# ENG-SF19004-R3-FDR-Redlines Summary\_Markup Summary

# ENG-SF19004-R3-CD-Redlines Summary\_Markup Summary

# ENG-SF19004-R3-SC-CD-Redlines Summary\_Markup Summary

# ENG-SF19004-R3-GEC-Redlines Summary

**HOMESTEAD AT STERLING RANCH FILING NO. 2**  
GRADING PLAN  
DATE: 03-03-2020  
PROJECT NO. 09-007  
SCALE: HORIZONTAL: 1"=50' VERTICAL: N/A  
DESIGNED BY: DLM  
DRAWN BY: JWP  
CHECKED BY: VAS

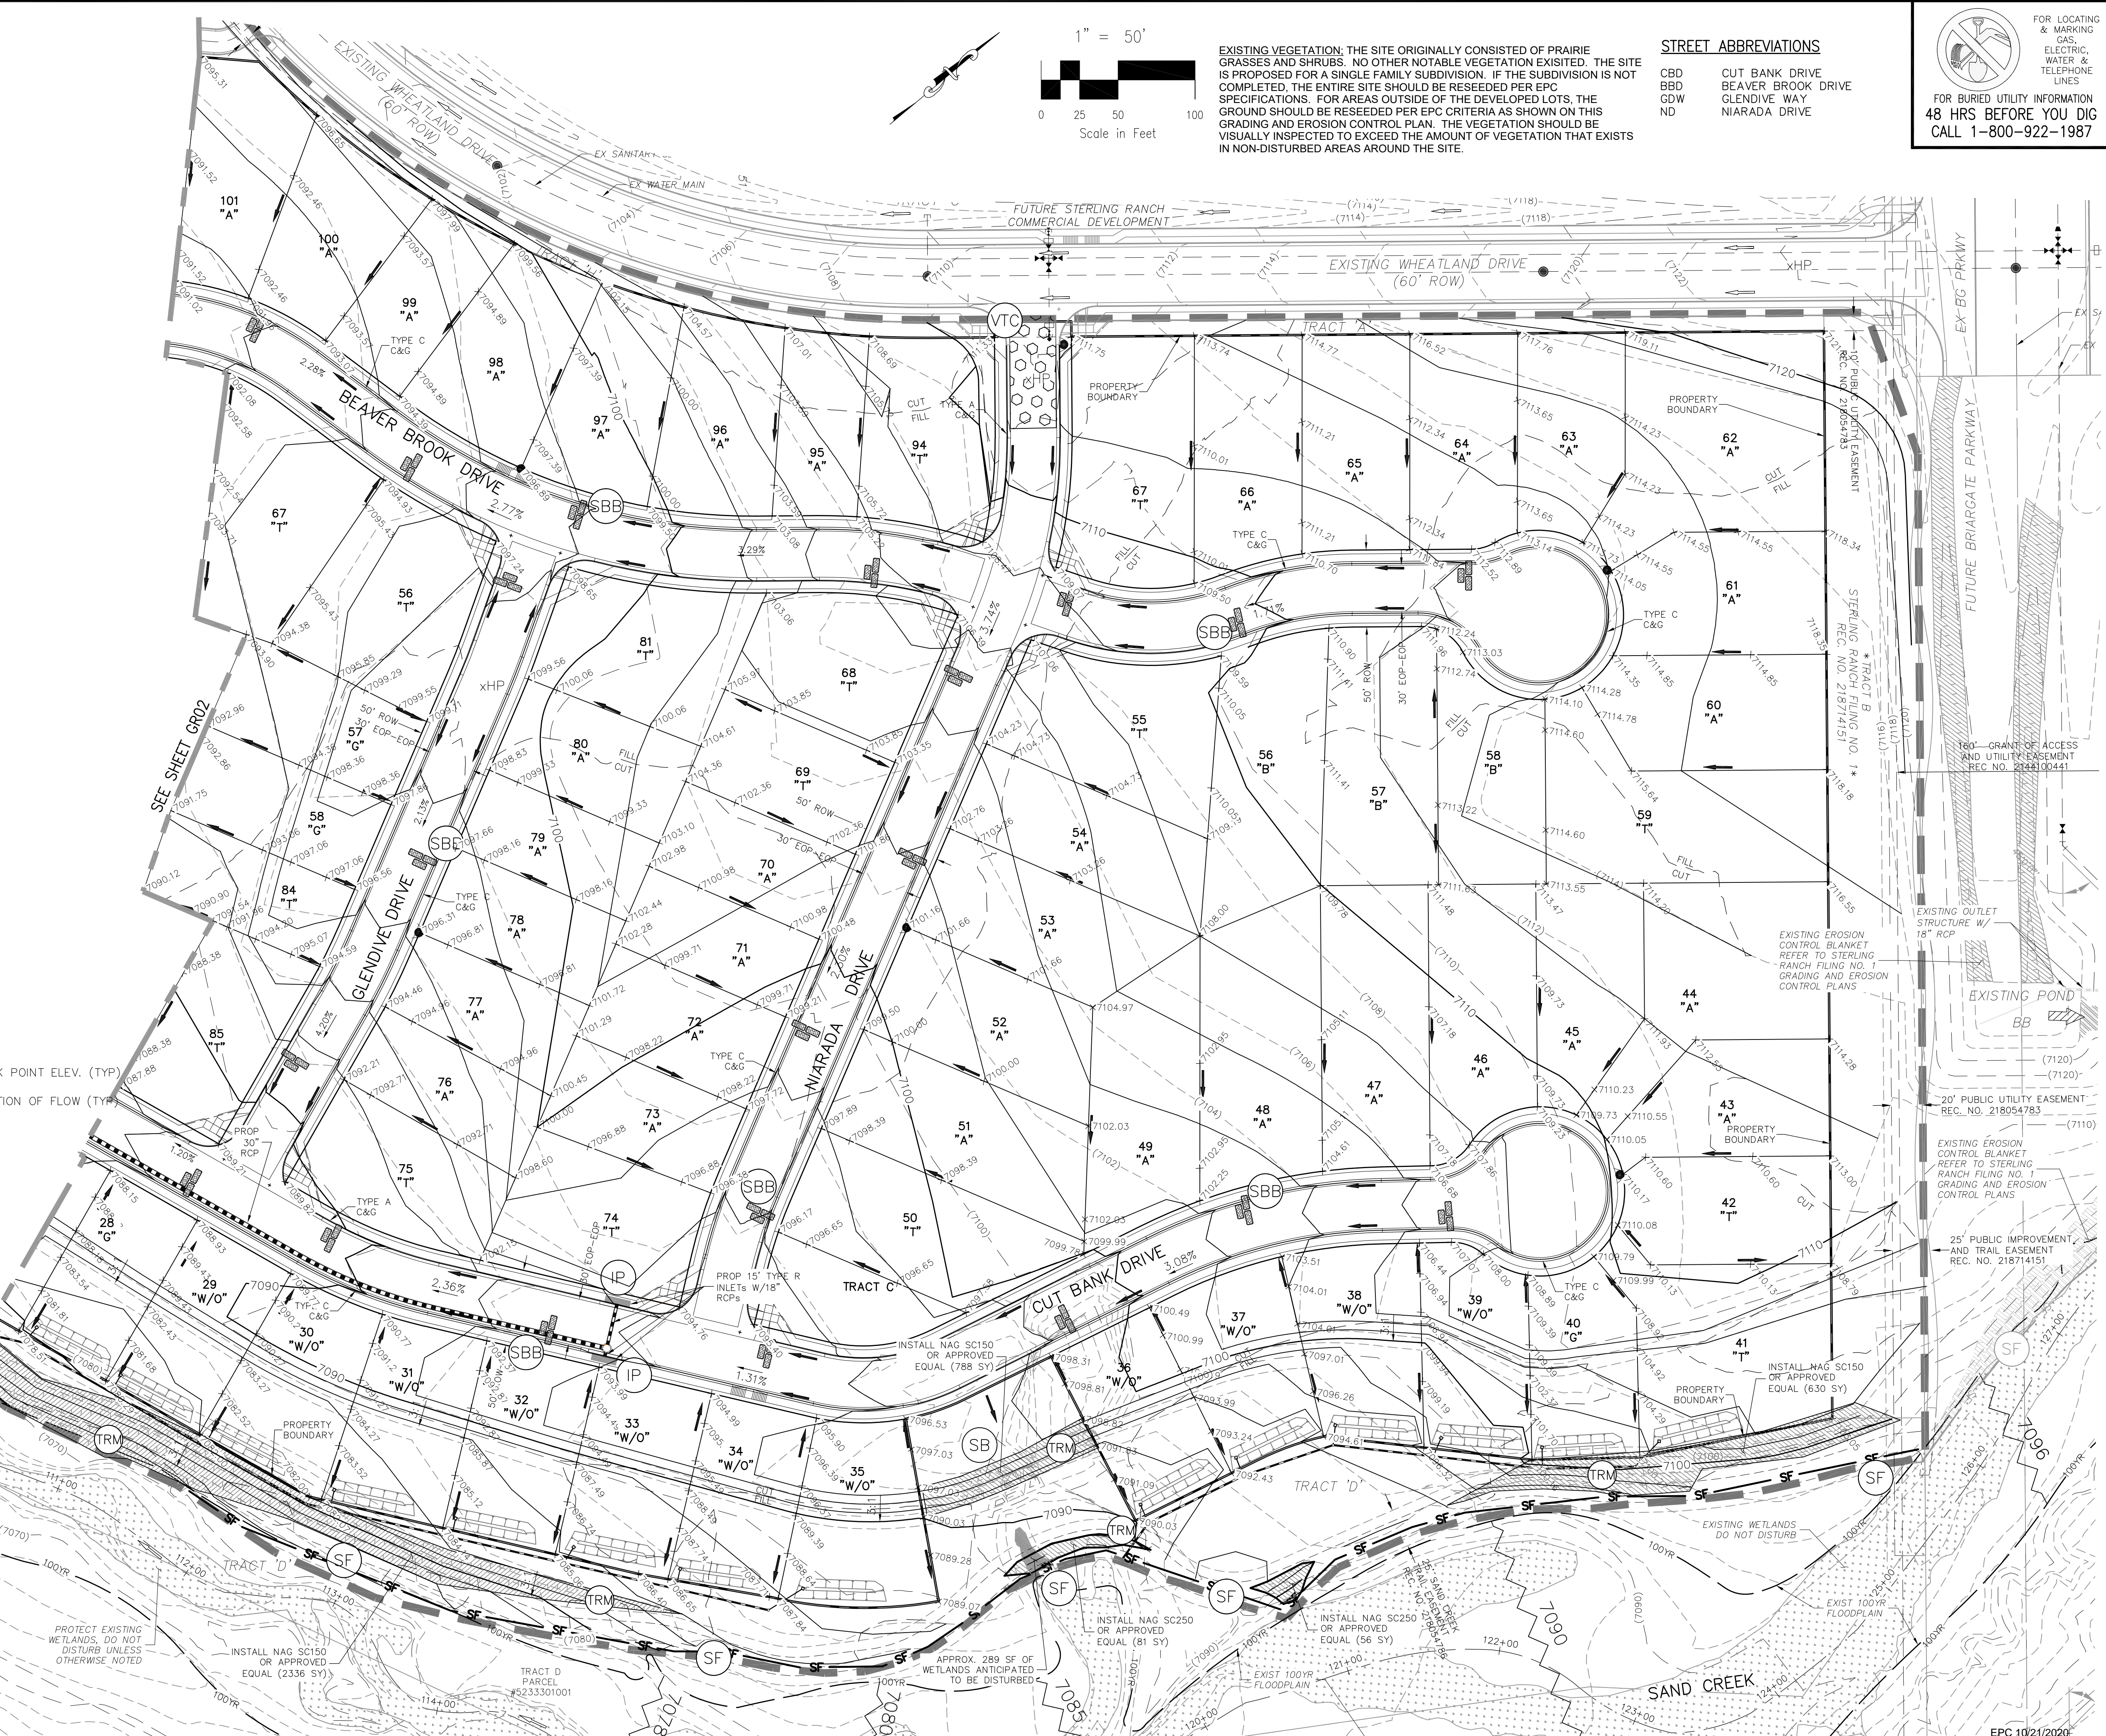
Call out how these SFB's will be constructed and their timing. Could the depressions be constructed to act as sediment traps ? during a phase of construction?  
This could also address the wetlands protection issue which is an outstanding comment from the version 1 plans.

Future trail/access road was removed from version 1 review? Where is the Channel access road?

Call out the pond name and call out what sheet has the details.

If the trail is being used to access PBMPs it needs to be provided.

24" OUTFALL INTO SAND CREEK
1"=5'

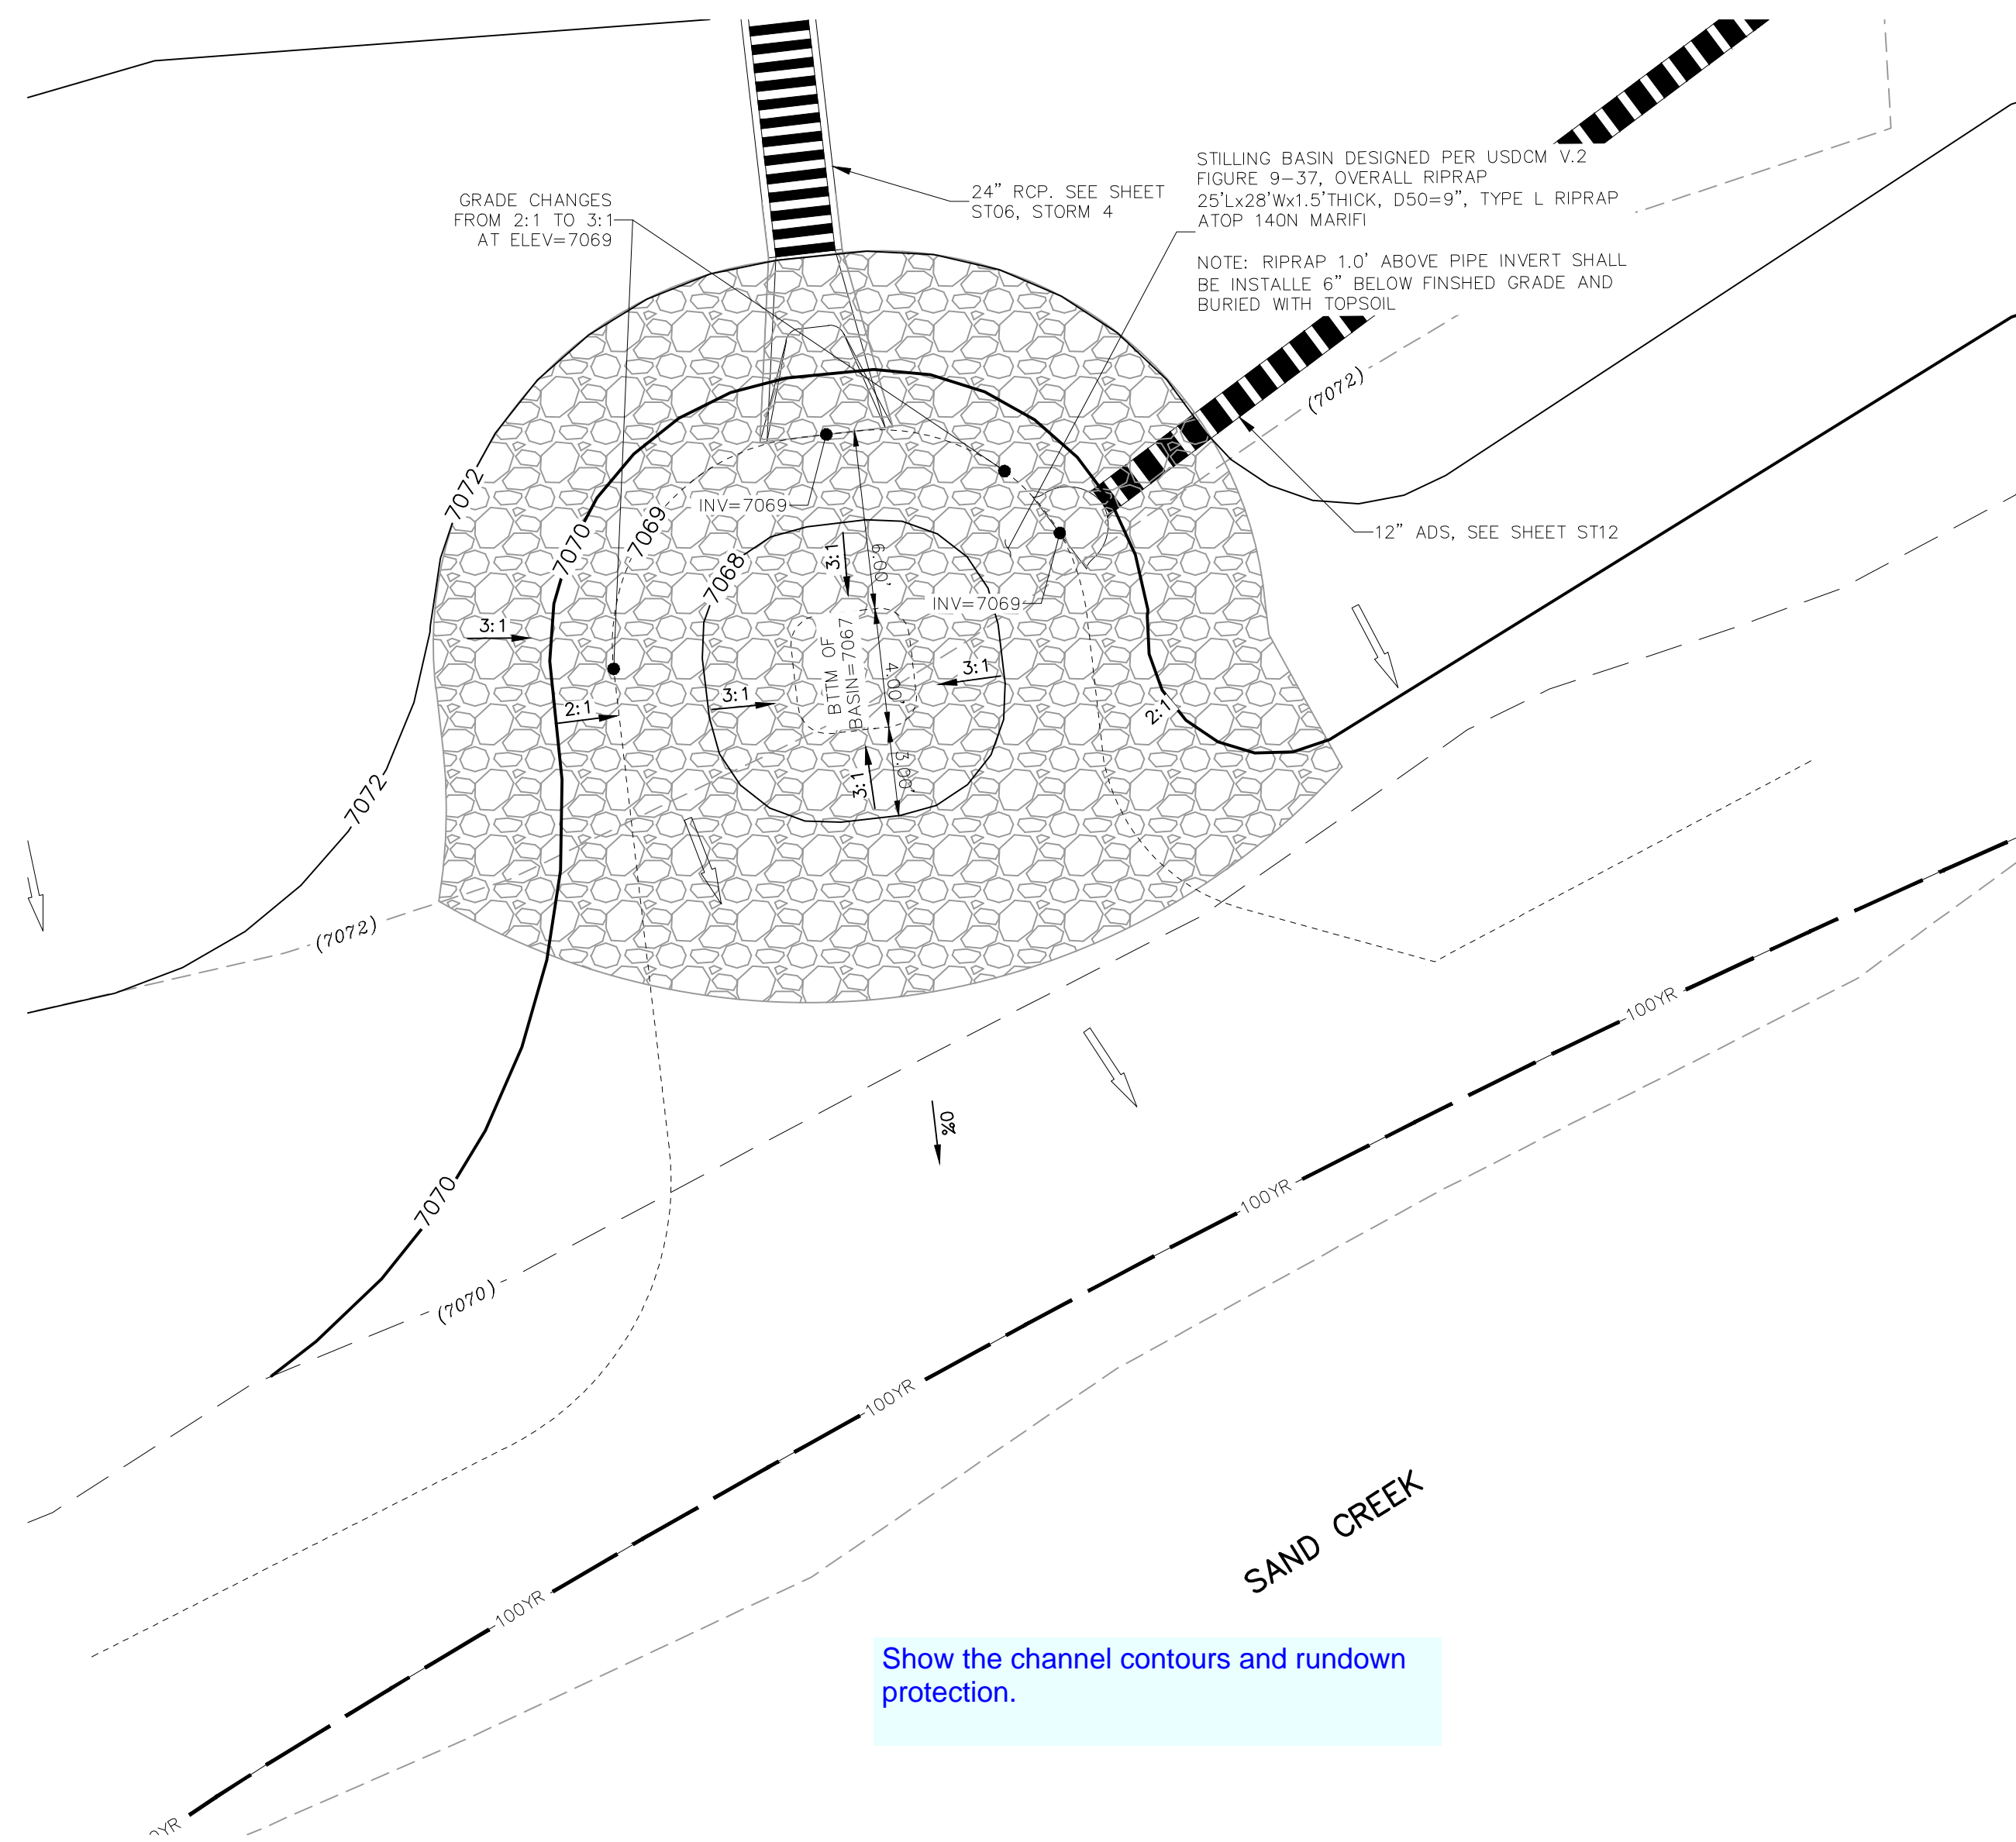
Show channel contours and rundown protection.

MATCHLINE SEE SHEET S109

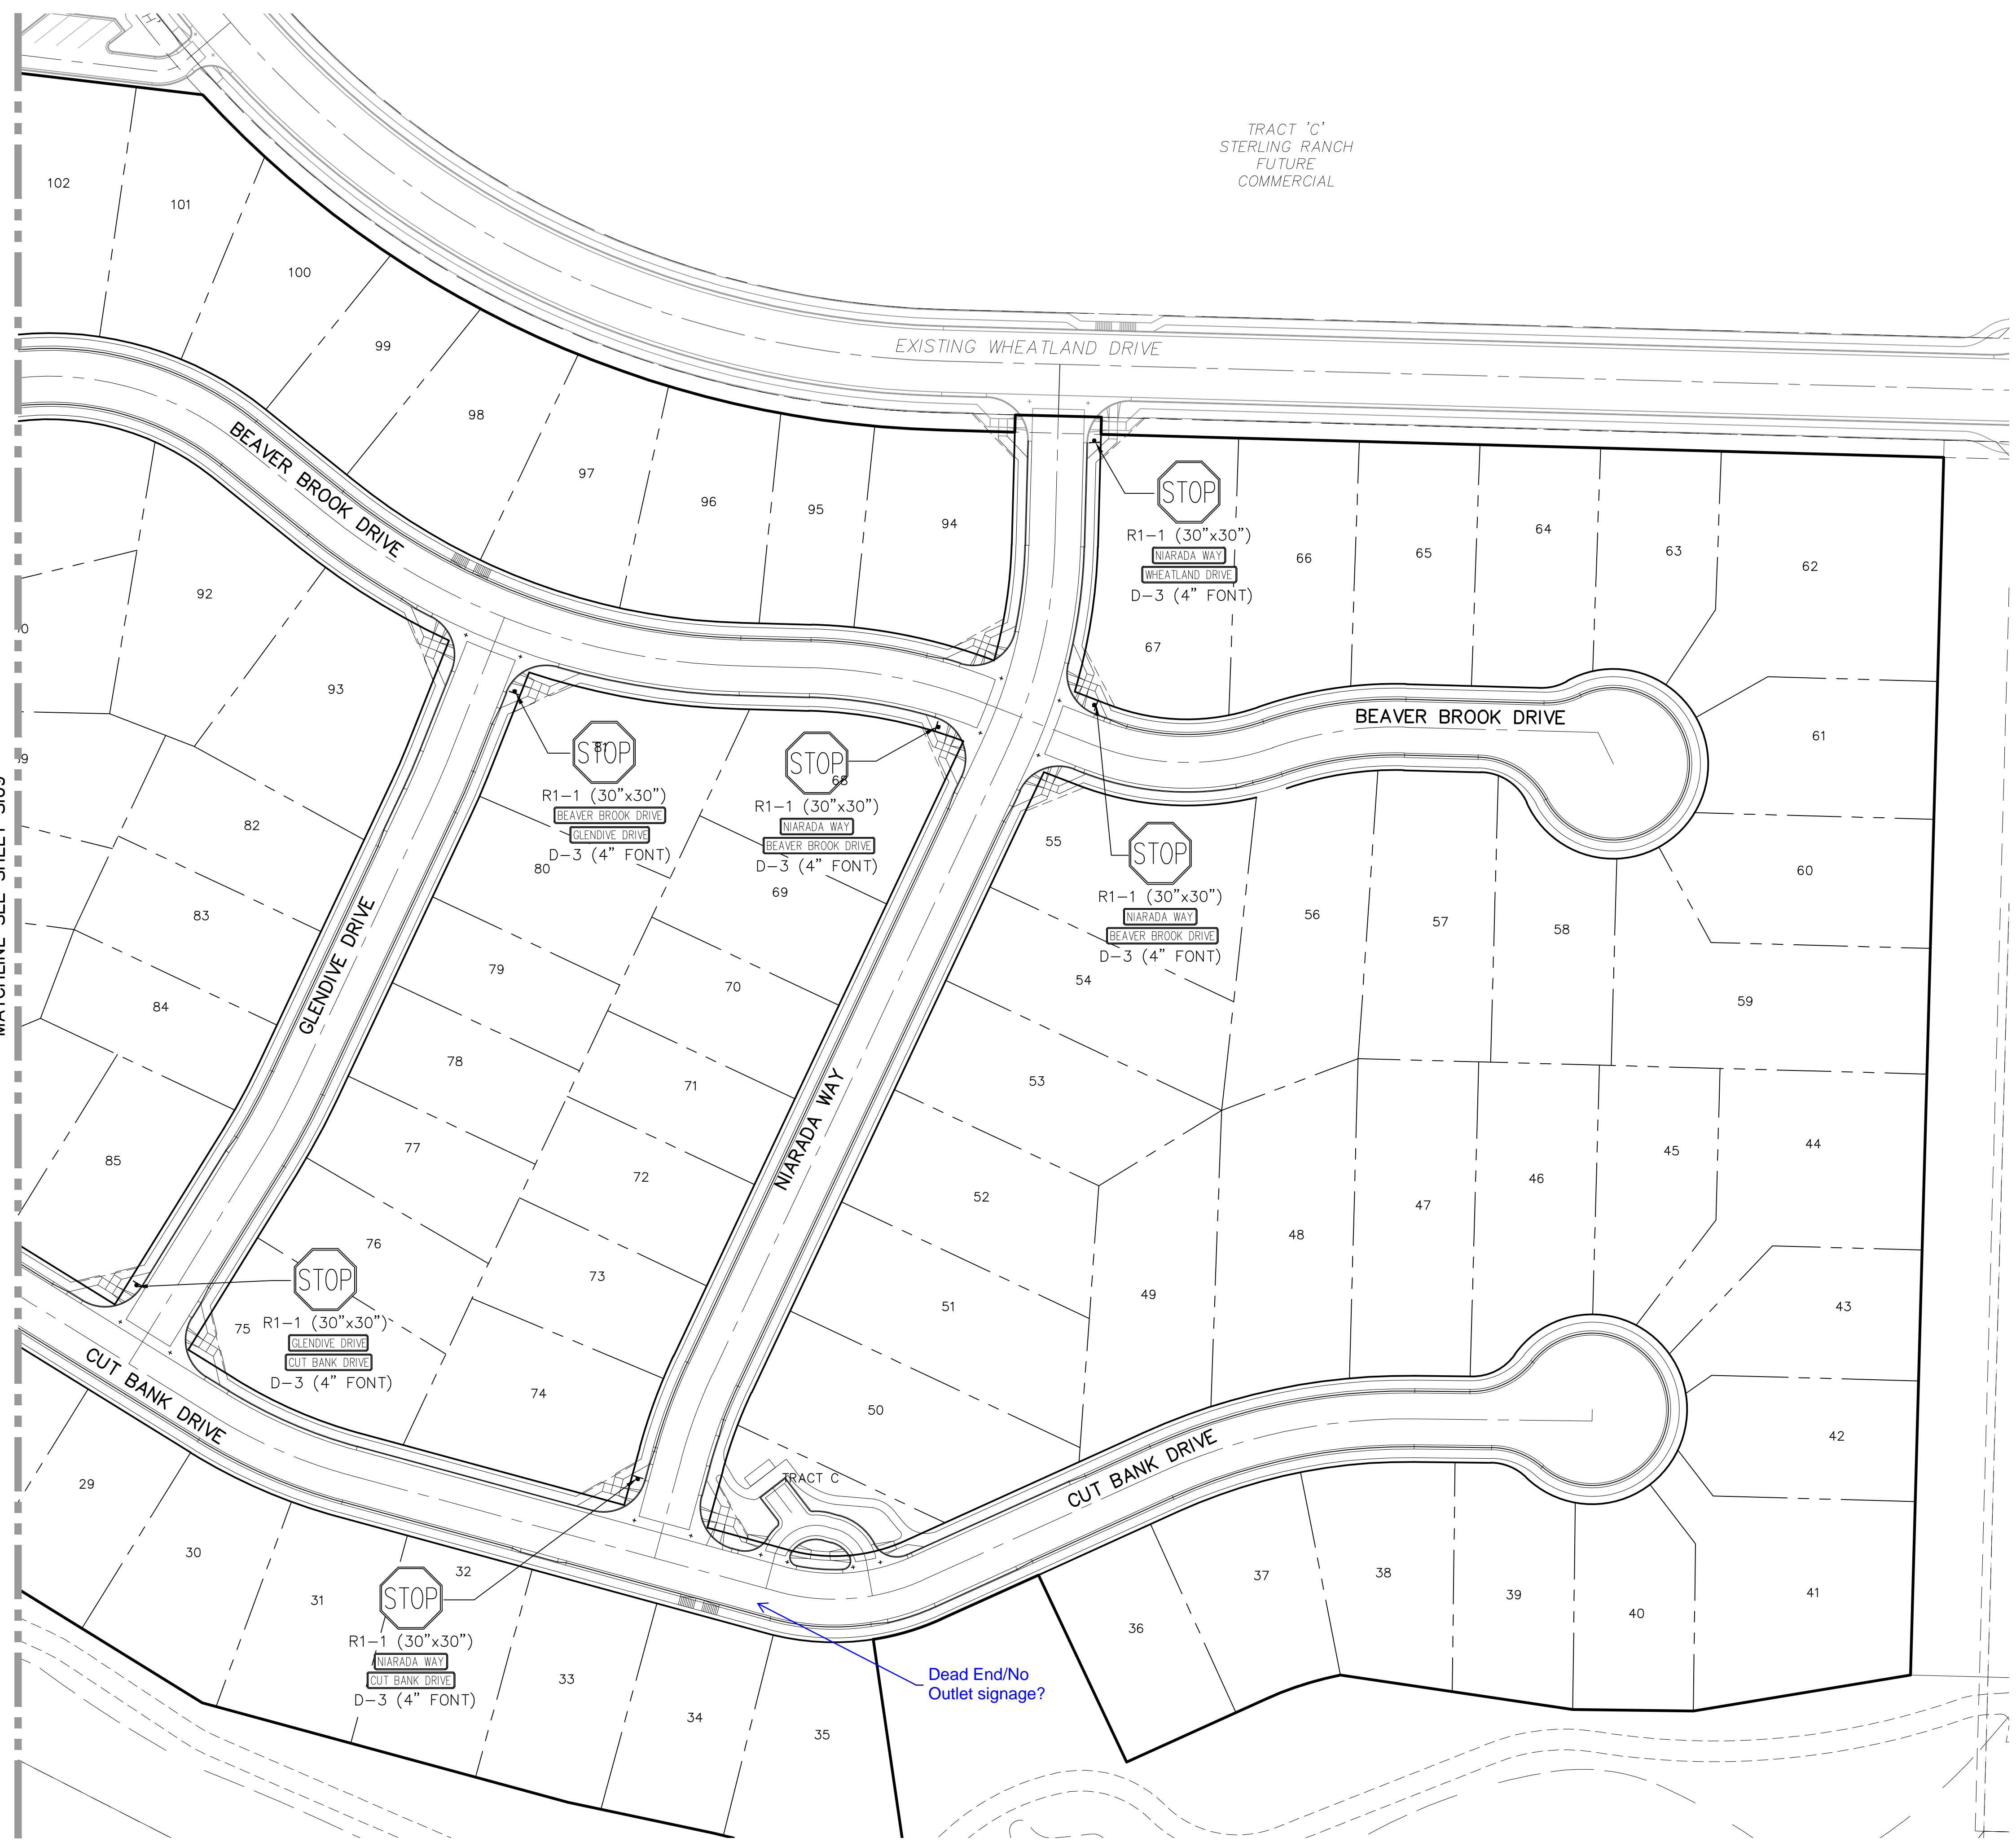
Dead End/No Outlet signage?
